Rezoning Petition Review

Rezoning Petition #: 20-173

Location of Property: Approximately 9.3 acres located south of Carolina Lily Ln and west of Mallard Creek Rd

SCHEMATIC SITE PLAN

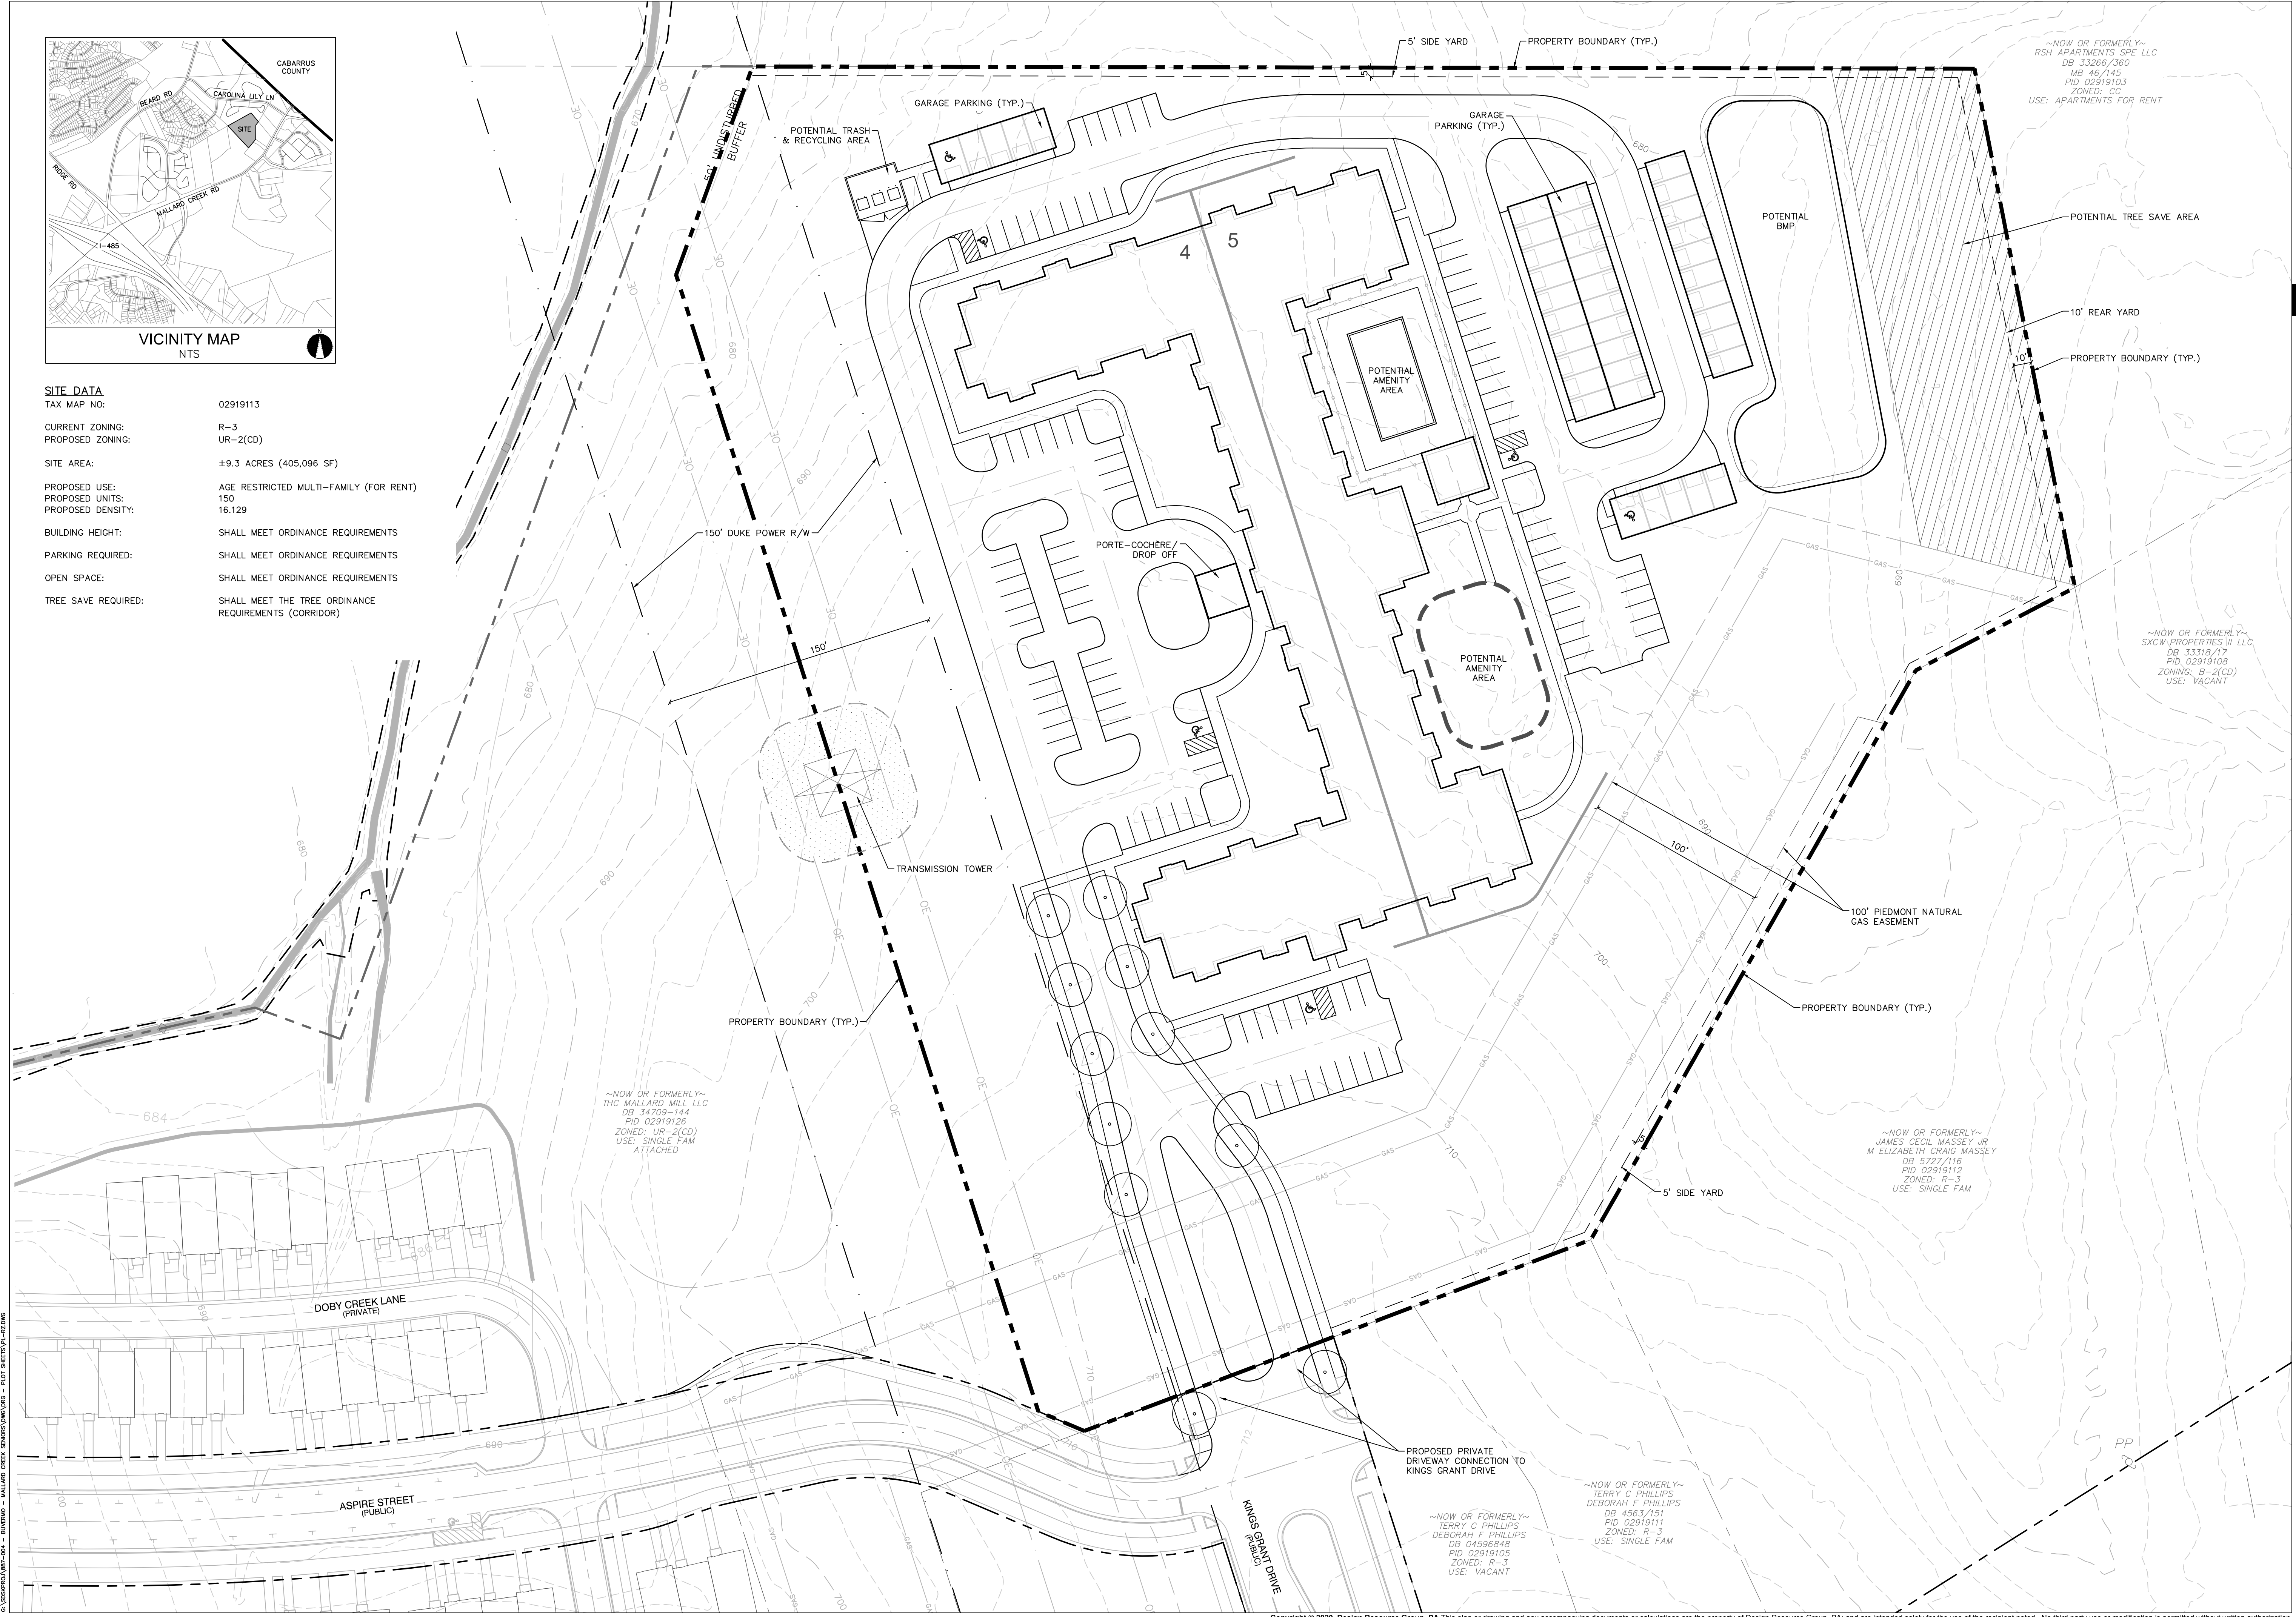
Environmental: Stream/wetland survey required prior to approval of civil site plan to ensure accurate delineation of top-of-bank/stream buffers/creek path and identification of any protected wetlands that may be on the site.
